From: Nicola Spencer
Sent: 15 March 2018 09:16
To: Karen Parsons
Subject: FW: 84 North Lane. Rustington. Ref. R/13/18/HH

I have had a chance to discuss the application with the team leader for this area and would make the following comments

1. I note that attempts have been made to address the previous refusal and there is a reduction in height from the previous, effectively 3 storey scheme. In addition, the amendments have been submitted which alter fenestration of the porch and the rear doors and also confirm the use of obscure glazing in first floor windows. However, as far as I can see the size of the proposed dwelling remains unchanged in height and footprint. In addition, the proposal is still sited as initially proposed. Whilst these changes are helpful there are still concerns as detailed below.

DWG. No. 1712081/PL/4A

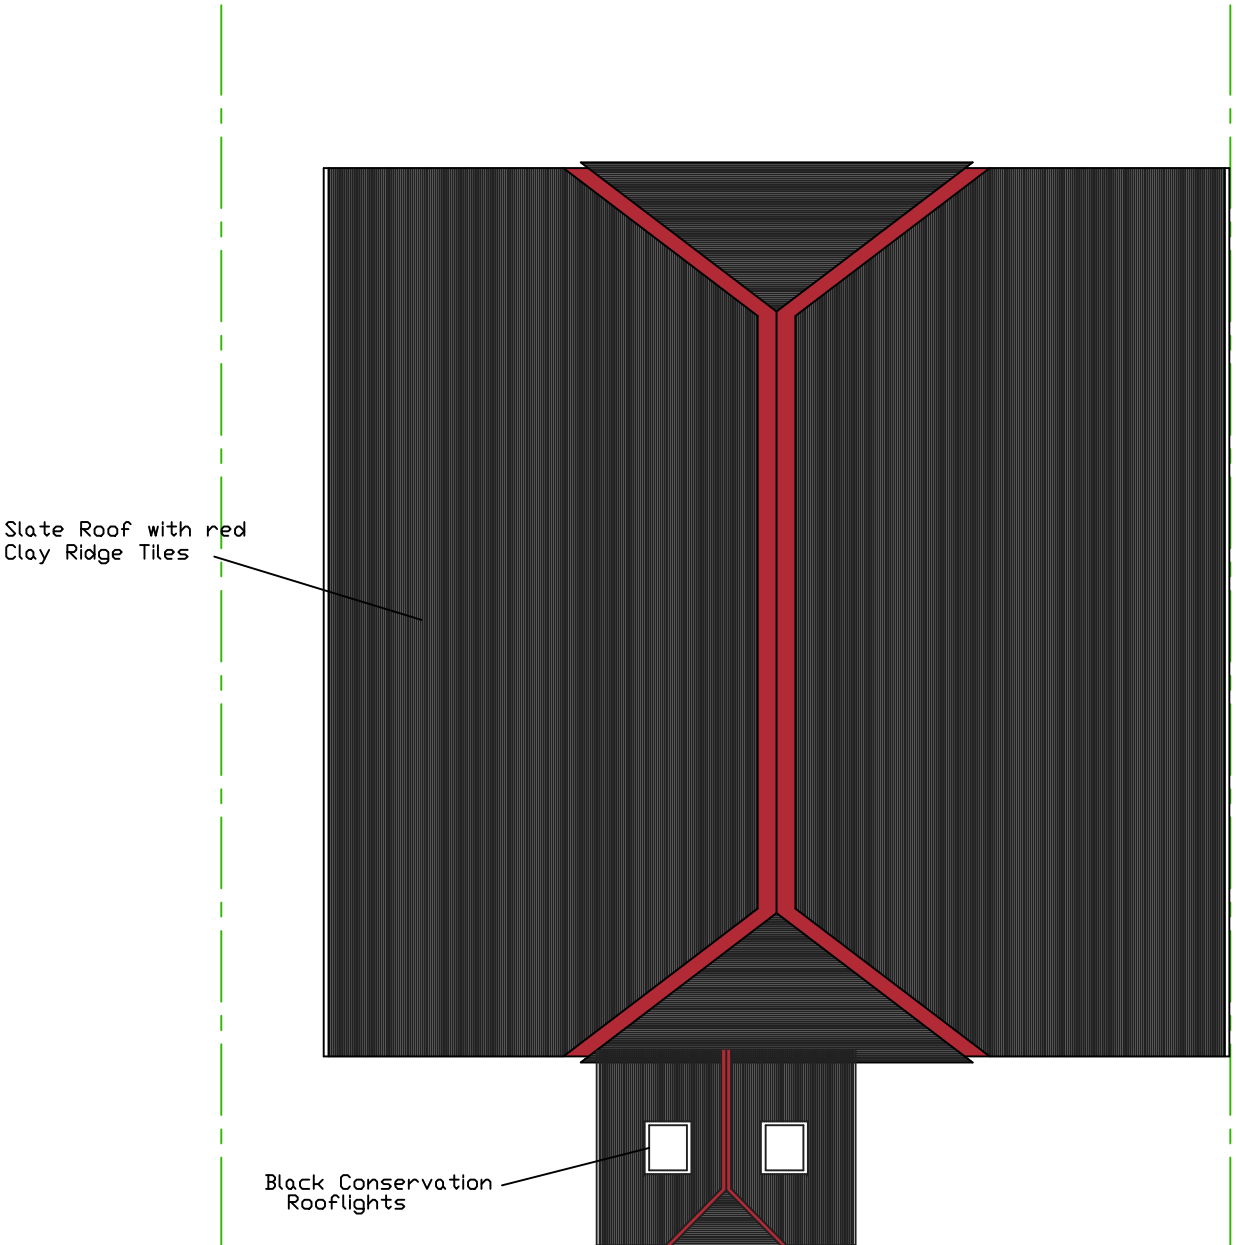
8. Therefore, at present the application will be recommended for refusal. However, if you feel you can address any of the above points please let me know. I appreciate your client may be wanting to utilise room in the proposed roof space in the future but the height of the proposal may need consideration in any revised proposal as the height and width contribute to the issue above.

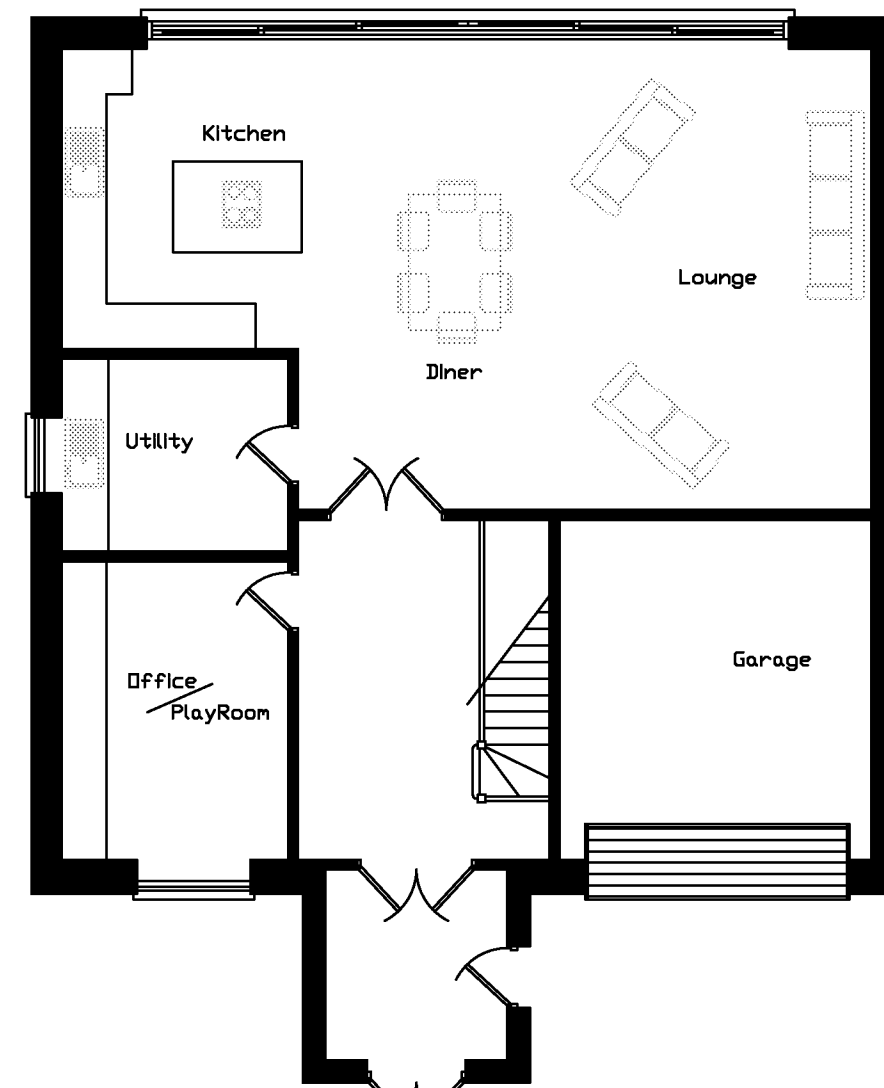
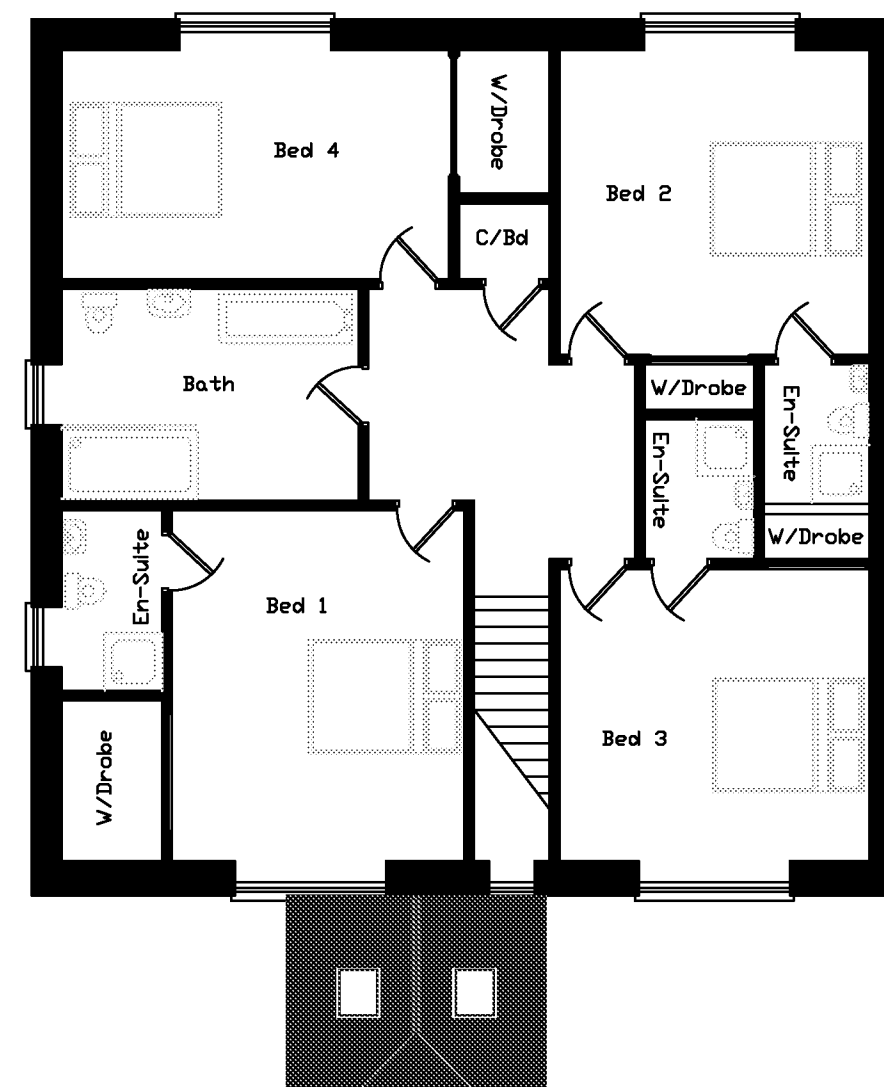
6. The proposed scheme comes close to the southern boundary and appears to be less than a metre at the front and touching the boundary at the rear. It is only 1 m off the boundary on the northern side. This is a significant change to the existing property and given the two storey height and also the high ridge level in excess of 9m. The proposed development appears cramped and unduly dominant. Furthermore, it is considered that the prevailing character does not comprise properties which effectively fill the plot width at least two stories. It is felt that the overriding character is properties with a more space to the side boundaries. Where a greater plot width is present these tend to involve reduction in heights to single storey for example.

7. Whilst the depth has been reduced and the proposal appears to address side windows so as not to lead an unsatisfactory loss of privacy. The proposed two storey development coming so close to the southern boundary is in my opinion unduly dominant upon the occupiers of the neighbouring property, whose rear building line is set back behind the proposed rear elevation of the current development. They also have windows in the rear elevation at ground and first floor level and as such there may be an impact on these, as such this aspect should be addressed. This impact is less to the northern boundary due to the position of the neighbouring dwelling and separation distance.
